From: Sue Howell <Sue.Howell@arun.gov.uk>
Sent: 04 October 2021 16:49
To: Planning.Responses <Planning.Responses@arun.gov.uk>
Cc: Michael Eastham <Michael.Eastham@arun.gov.uk>
Subject: RE: Planning Consultation on: BE/121/21/RES

Application ref: BE/121/21/RES

Description: Approval of reserved matters following BE/135/18/PL for appearance, landscaping and layout of Unit 3. This application may affect the character & appearance of the Shripney Conservation Area & is in CIL Zone 2 (Zero Rated) as other development.

Location: Unit 3 Land At Salt Box West of Shripney Road Bognor Regis PO22 9NW

Proposed site plan

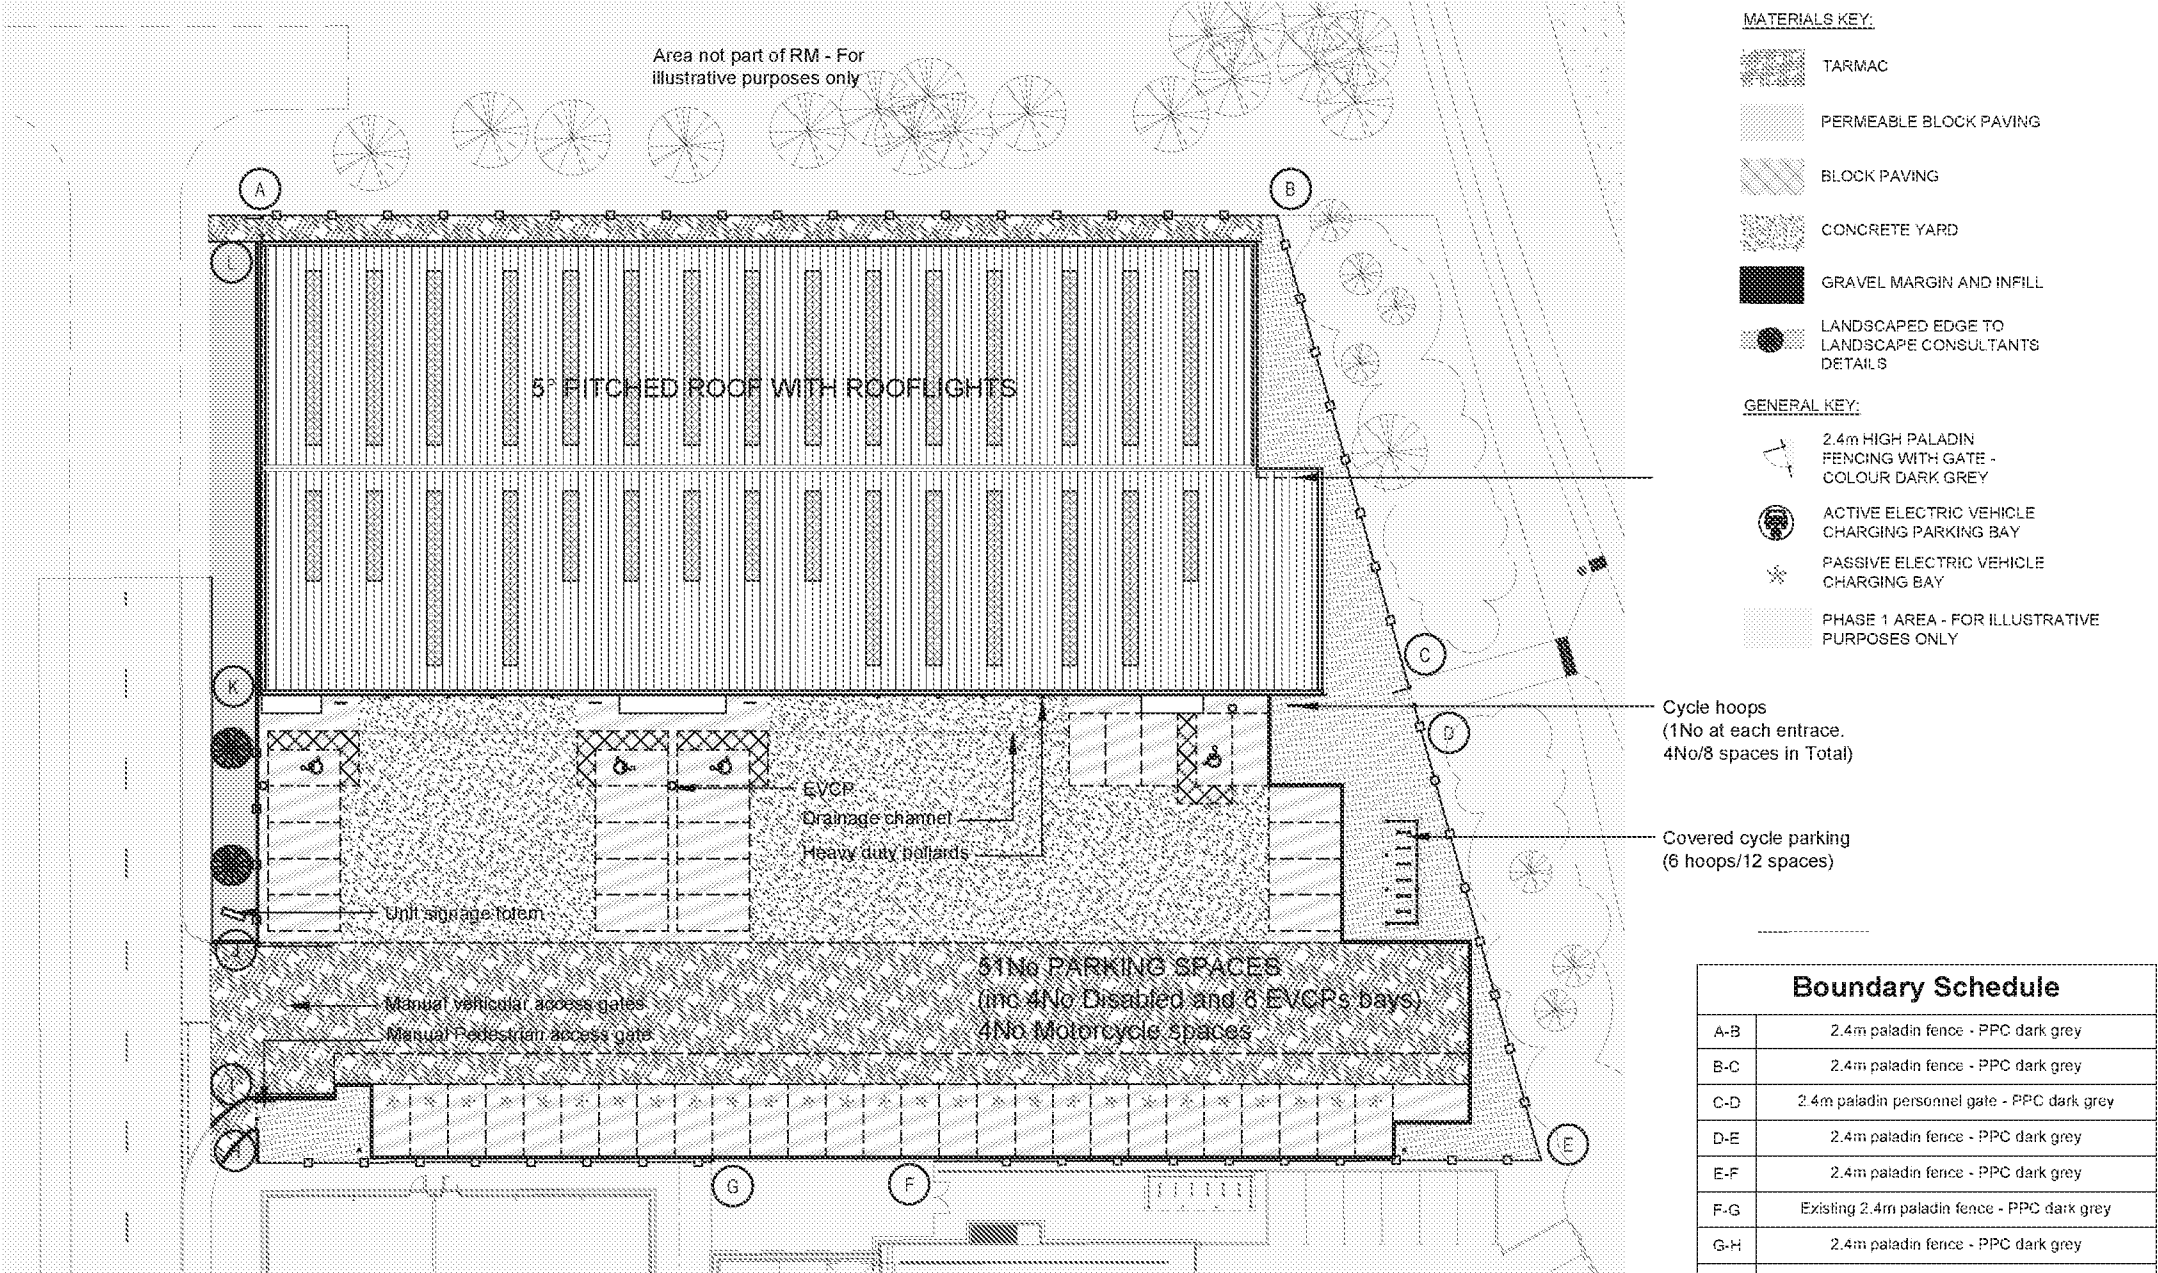
Following submission of Landscape proposals under dwg Unit 3 planting Plan 5920.PP.03.1.0.REV A and details submitted within Unit 3 Design Code detail, I would comment as follows:

The landscape scheme has been detailed to the westerly aspect of the building incorporating two ornamental trees and a section of continuous single species native hedging. The landscape detail whilst basic is suitable for location and of a species that will allow for maintenance of this into establishment.

The above drawings and Design Code have shown and referenced consented landscaping beyond the red line (not part of this application) to the north with landscaped bund and to the east with shown landscape indicated. These additional boundary treatments will aid in the screening and softening of the building structure in these locations.

The landscaping proposed would appear suitable for location and purpose.

Maintenance operations will be required to ensure establishment and ongoing maintenance required to retain the planting in hedge form.
